18 June 2024

HW Ref: HW2017-1215/18/64
Your Ref: SSD - 71547218

SEARs comments on proposed State Significant Development (SSD-71547218) - Kurri Kurri Integrated Resource Recovery Centre - Styles Street, KURRI KURRI

**Proposed Site Plan**  
 Scale: 1 : 500

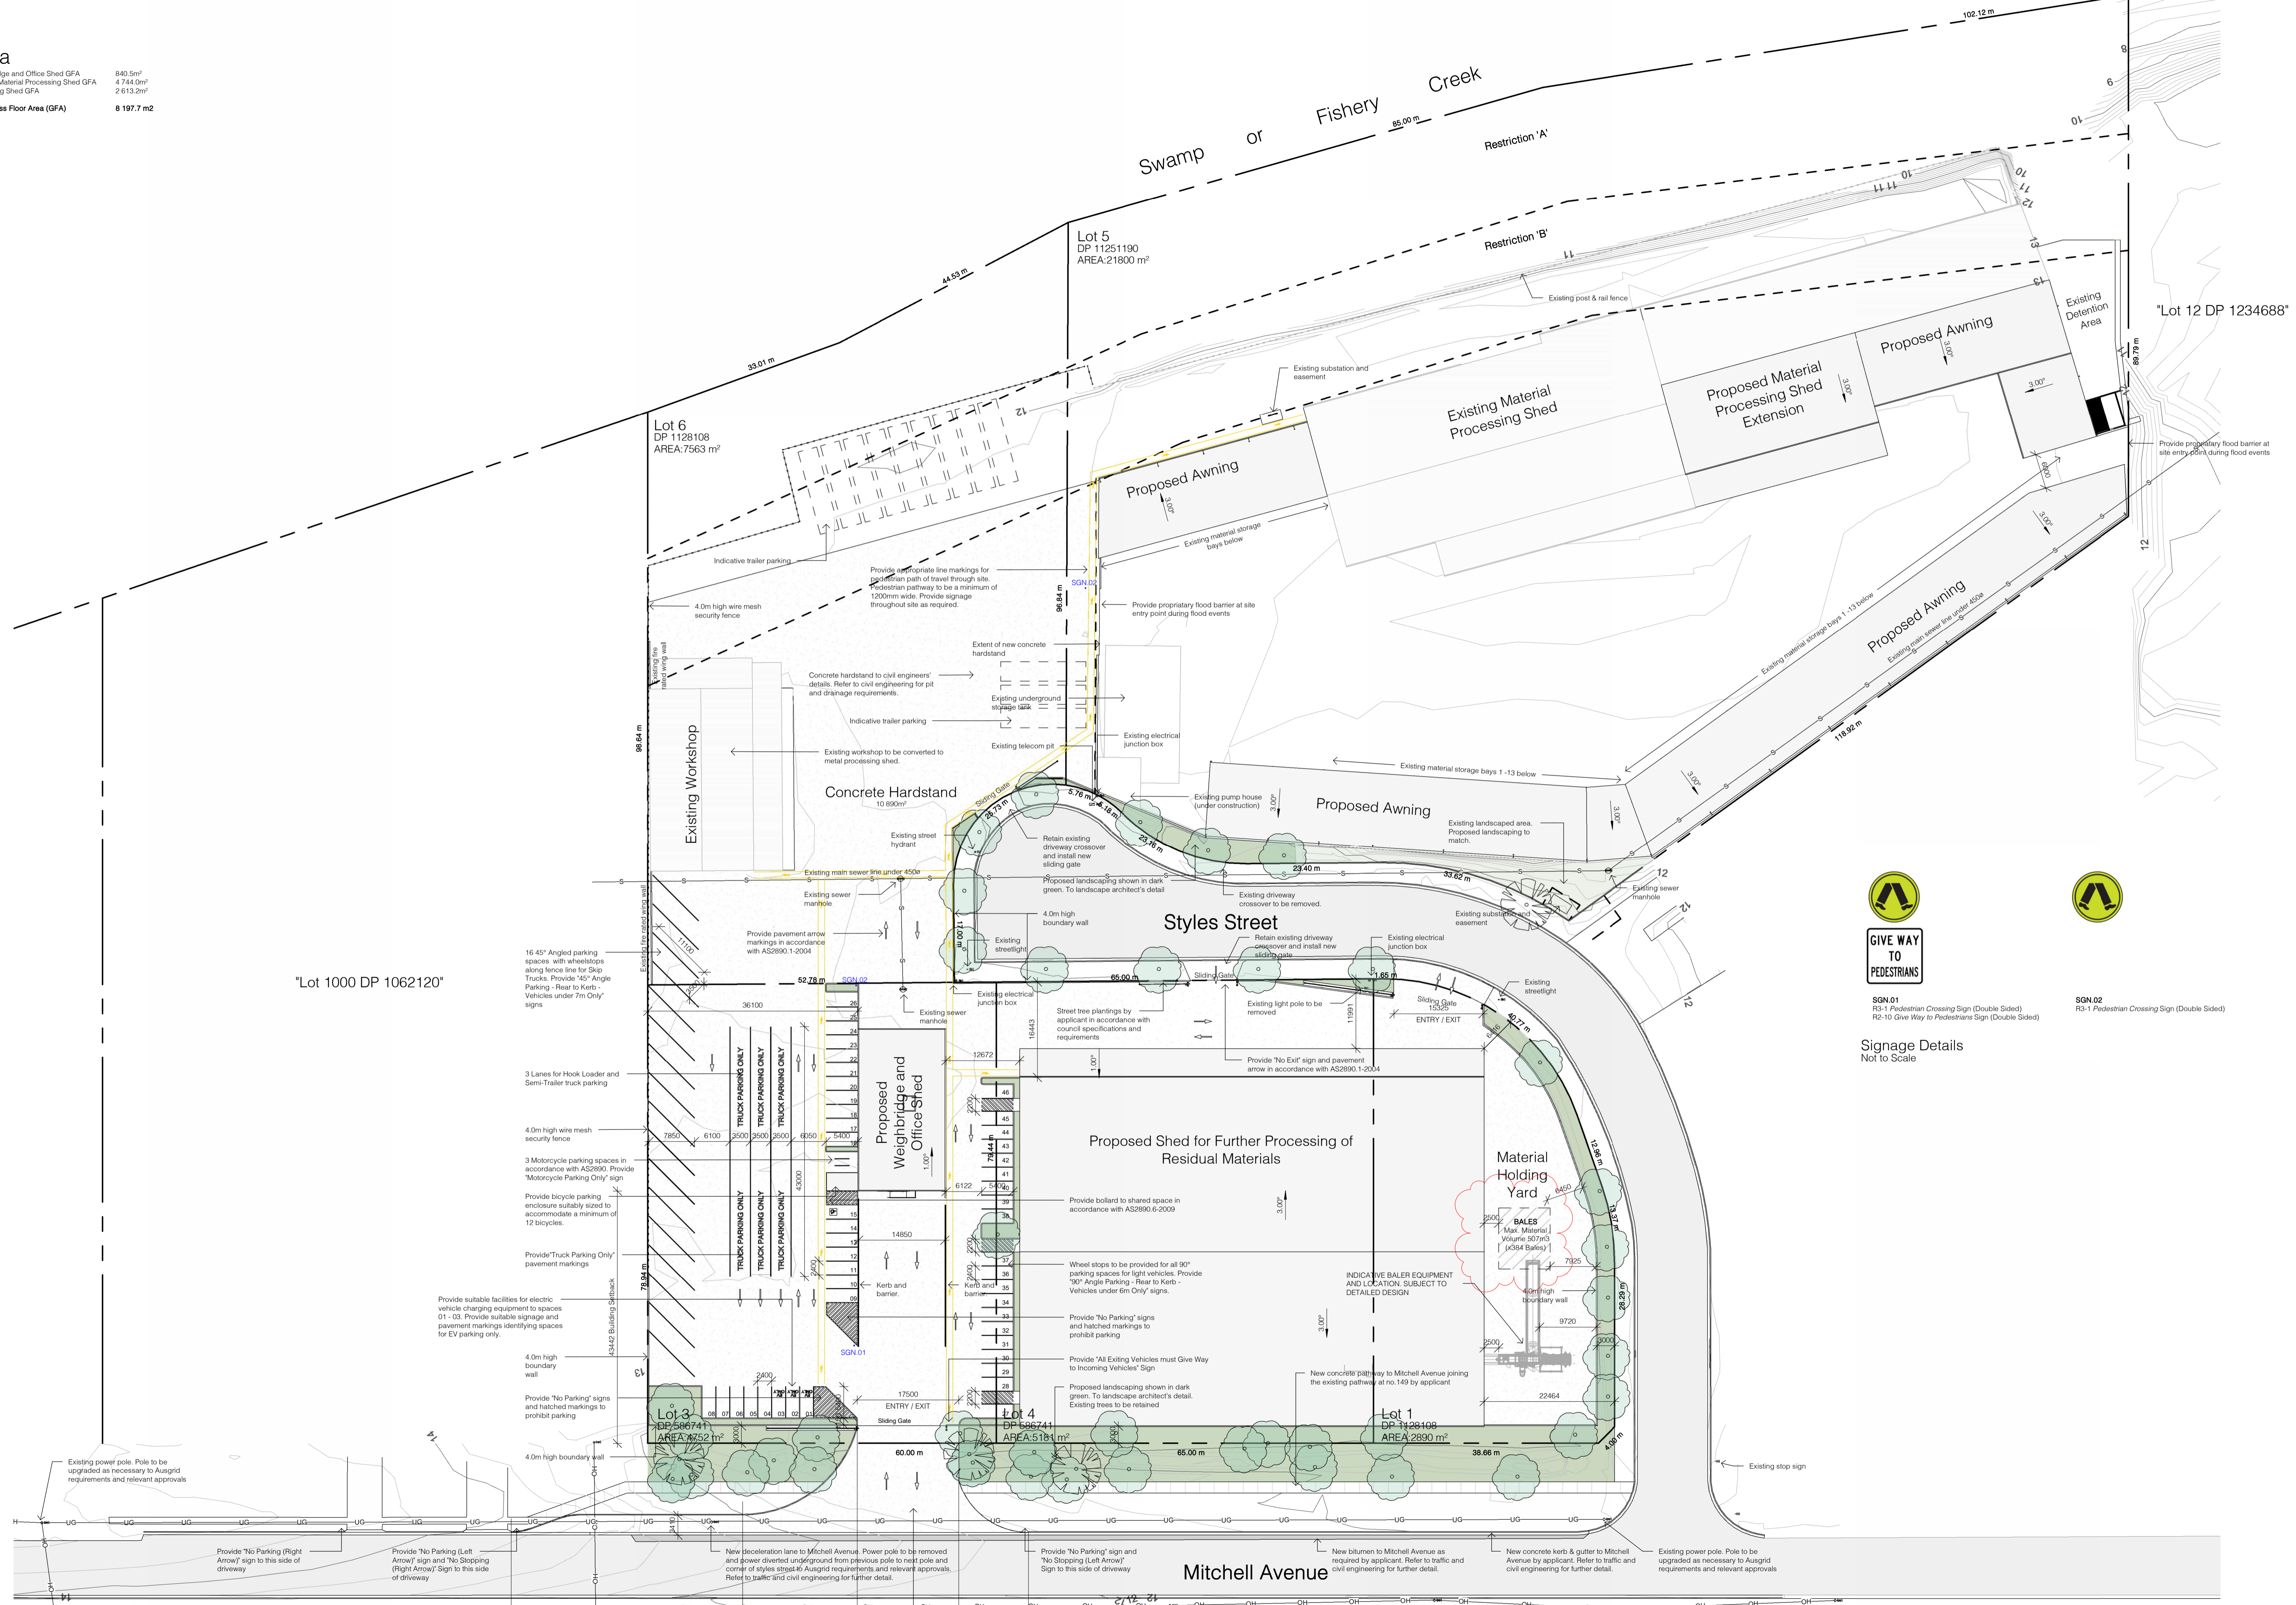
As indicated in *Section 5.3 Engagement for previous application*, Hunter Water noted the presence of a 450mm trunk sewermain under the site and provided requirements for works over sewer assets, and subsequently registered an interest in the development proposal. The Proponent was requested to undertake further consultation with Hunter Water on this matter.

The trunk sewermain is a critical asset and a failure will have a significant impact on the residents of Weston and Abermain. The proposed awning structure on Lot 5 will impede our access to the sewermain for maintenance and repairs, and Hunter Water will require the Proponent to either:

- i. Relocate the awning clear of the sewermain to provide the necessary clearance to allow excavation of the sewermain; or
- ii. Relocate the sewermain clear of the awing to provide the necessary clearance to allow excavation of the sewer main.
